Recommendation Report for Planning Permission for Works or Extension to a Dwelling

REF NO: LU/69/20/HH

LOCATION: 27 Tideway
Littlehampton
BN17 6PP

PROPOSAL: External cladding.

FRONT WEST ELEVATION
PROPOSED ELEVATIONS
Scale 1:100

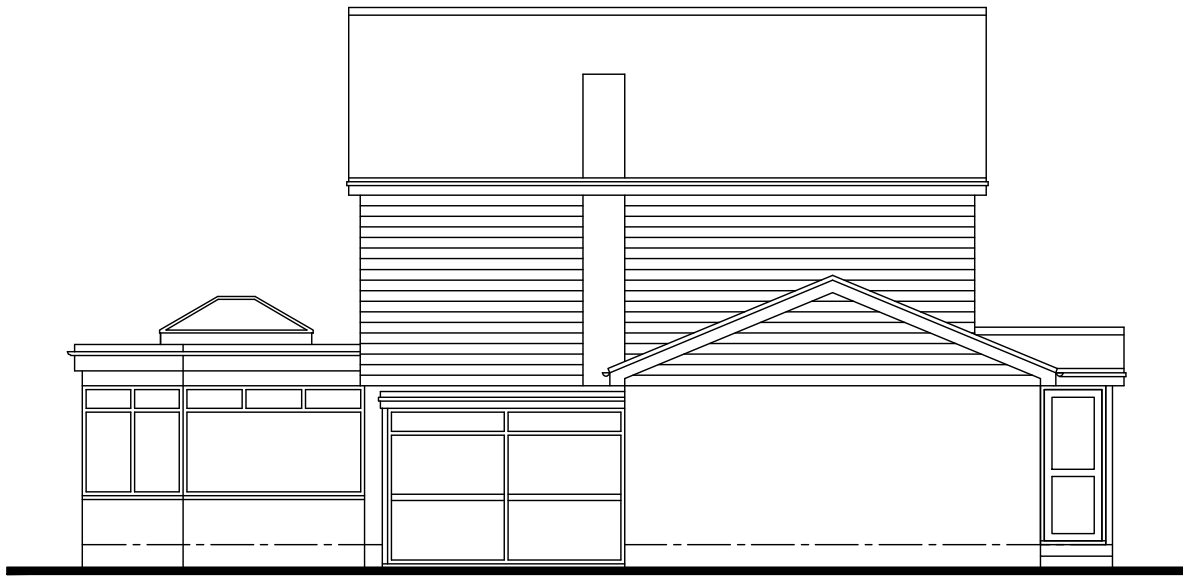
The dwelling is in an area populated by dwellings utilising a wide variety of building materials. The development seeks to clad the first floor in light grey weatherboarding. This is an acceptable alteration, by reason of its colour and design, to the dwelling having no significantly harmful impact upon the character of the dwelling, or its locality.
